Re: Non Material amendments planning application for planning ref:23/P/01069 at Purse Ryde Cottage. Westwood Lane, Normandy, GU3 2JF

Please note the following proposed amendments and information to assist in this non material amendment application.

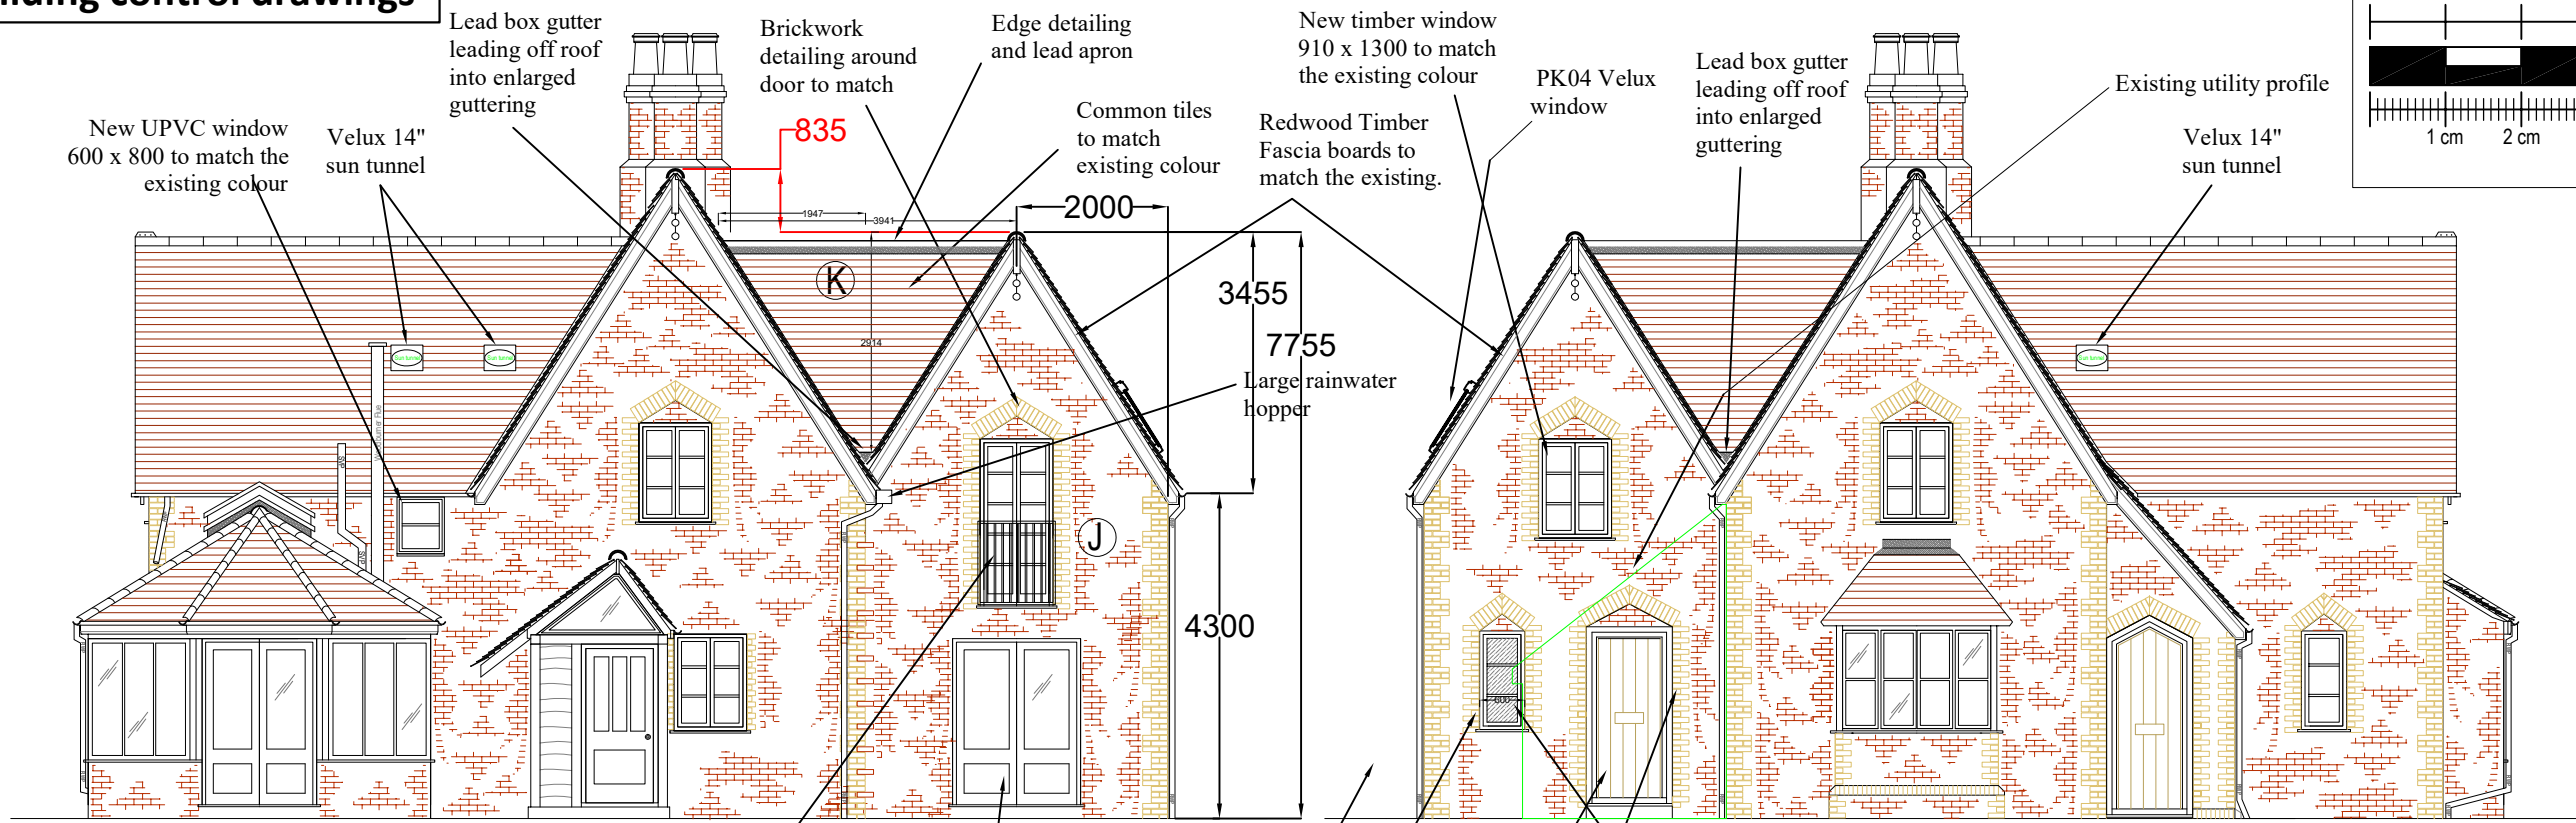
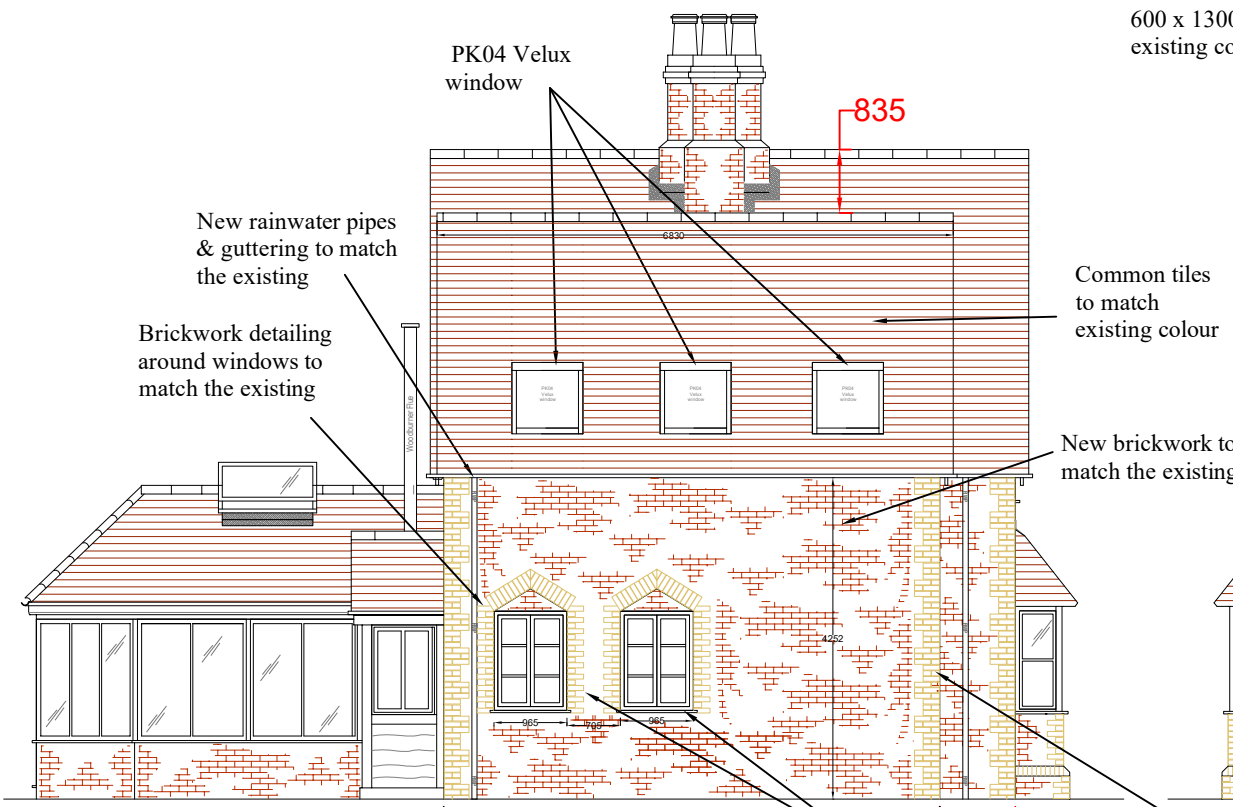
- The ground floor layout has been slightly altered around the entrance hall which meant that the side windows were in the wrong location and quite small. As a result it is proposed that the windows are to be increased in width from 600mm to 900mm wide. NO increase in high is being proposed. Both the windows are now in the dinning area to give more natural light into this area.

- No window overlook any neighbouring properties and so no additional overlooking is created as a result of this width increase.
- The side facing windows have been increase slightly in size to give more light into the new bedroom 4. An additional velux window has been proposed in the ensuite to give more natural light. All velux windows have been repositioned to have equal spaces in the roof.

- It is proposed that the existing front door is to be retained and not replaced with a new window.
- It proposed to change the bedroom 4 glass balustrade with a brushed steel guarding.
